# ENVIRONMENTAL STATEMENT: 6.3 APPENDIX 4-2: SCOPING OPINION RESPONSE

## Cory Decarbonisation Project

PINS Reference: EN010128

March 2024

- Legend**
- Site Boundary
 - Extended Local Nature Reserve (LNR)

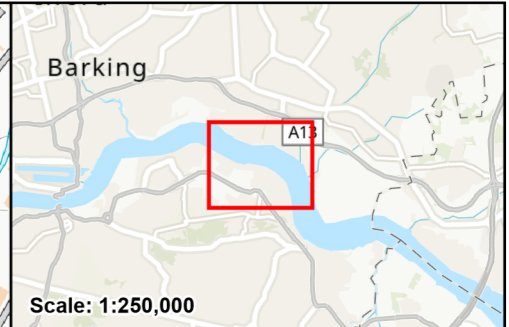
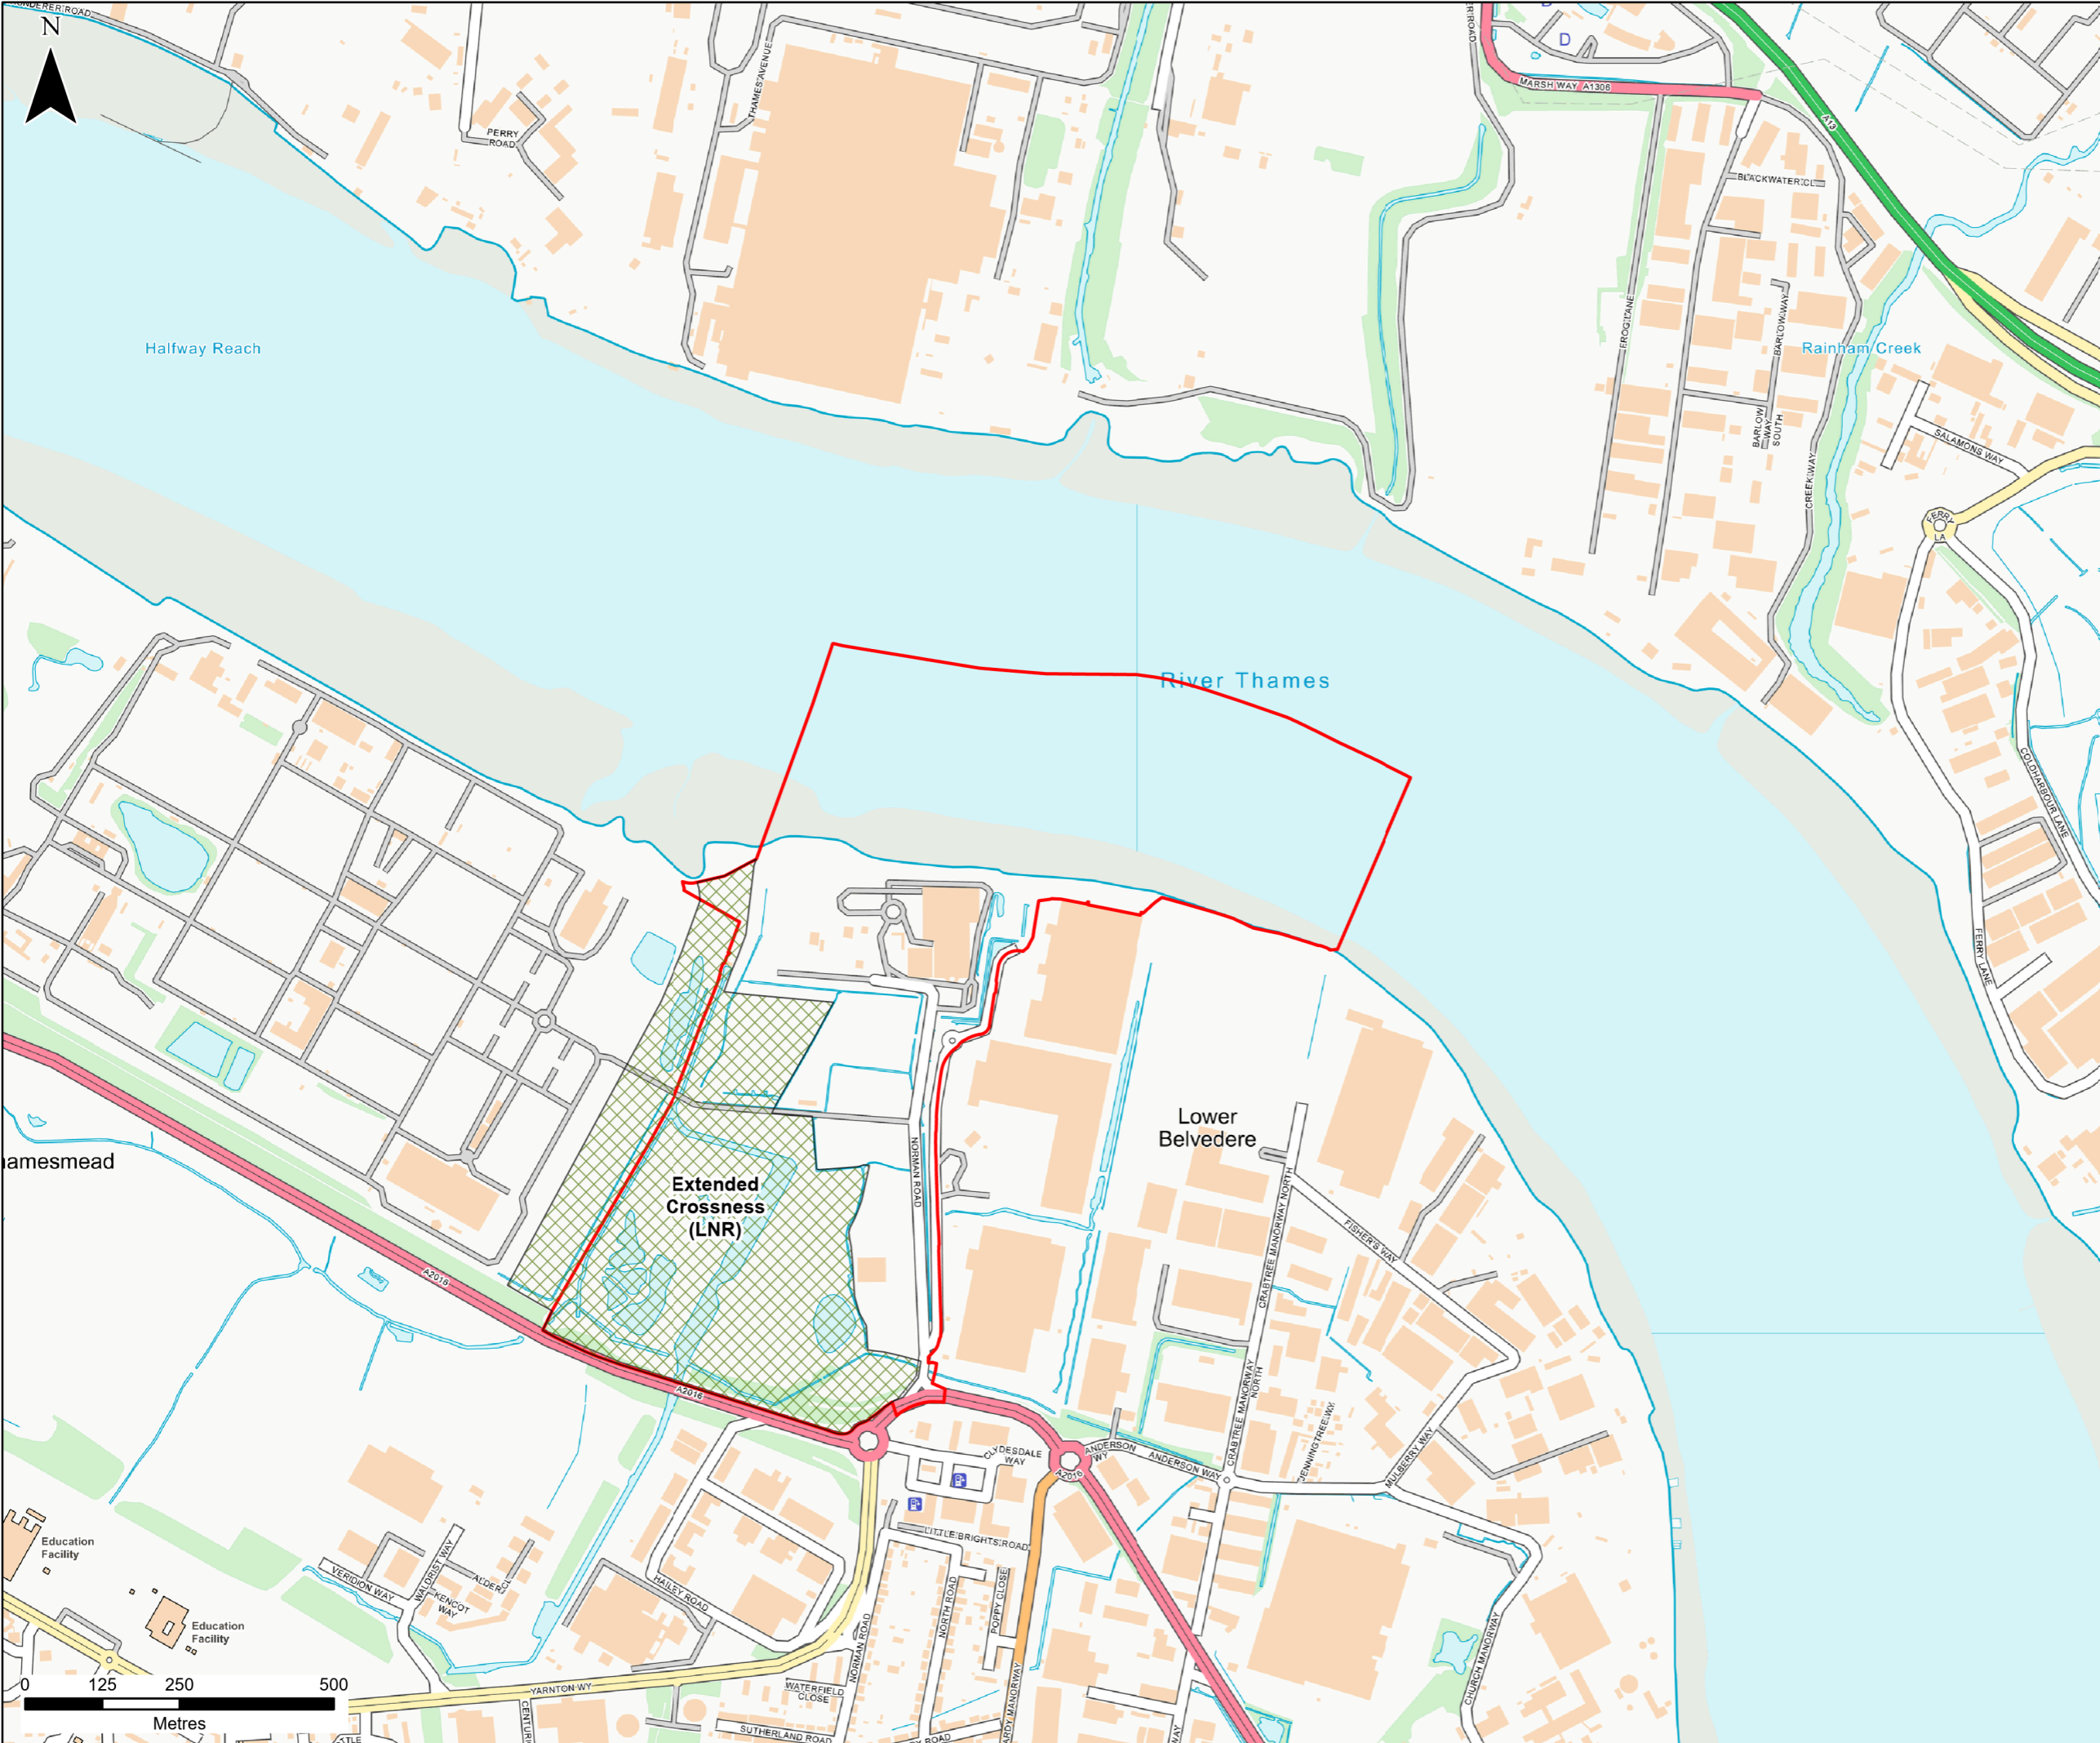
2.1.6	<p><i>“Paragraph 2.1.17 states that “A portion of the Crossness LNR is proposed to be included in the Site Boundary” and paragraph 6.6.2 states that “The Proposed Scheme will likely result in the loss of part of Crossness LNR”. The ES should quantify the amount of land within the Crossness LNR which is located within the application site and describe in detail the works which would take place within the LNR.</i></p>	<p>The amount of land of the Crossness LNR within the Site is described and quantified in <b>Chapter 7: Terrestrial Biodiversity (Volume 1)</b>. The works likely to take place within the Crossness LNR are described in <b>Chapter 2: Site and Proposed Scheme Description (Volume 1)</b>, the <b>Outline LaBARDS (Document Reference 7.9)</b> and also</p>

Section ID	Scoping Opinion Comments	Response
	<p><i>The scoping consultation response from Thames Water (Appendix 2 of this Opinion) states that Crossness LNR was required to be provided and maintained for at least 99 years by a section 106 legal agreement associated with a previous planning permission. Where there is potential for the Proposed Development to impact on the Crossness LNR, the ES should include an assessment of relevant effects, including any effects on the ability to deliver outcomes required through the mitigation provided under the previous scheme.”</i></p>	<p>described within <b>Chapter 7: Terrestrial Biodiversity (Volume 1)</b>.</p> <p>The <b>Works Plans (Document reference 2.3)</b> shows the Mitigation and Enhancement Area, which is described in <b>Chapter 2: Site and Proposed Scheme Description (Volume 1)</b>.</p> <p>A summary of the historical commitments made by Thames Water in relation to the Crossness LNR are provided in <b>Chapter 2: Site and Proposed Scheme Description (Volume 1)</b>. <b>Chapter 7: Terrestrial Biodiversity (Volume 1)</b> assesses the potential ecological effects of the Proposed Scheme on the Crossness LNR and considers the ability of the Proposed Scheme to continue to deliver outcomes required under the previous permission. The <b>Draft DCO (Document Reference 3.1)</b> submitted as part of the application deals with the impacts of crossover with the Section 106 agreement and previous planning permissions.</p>
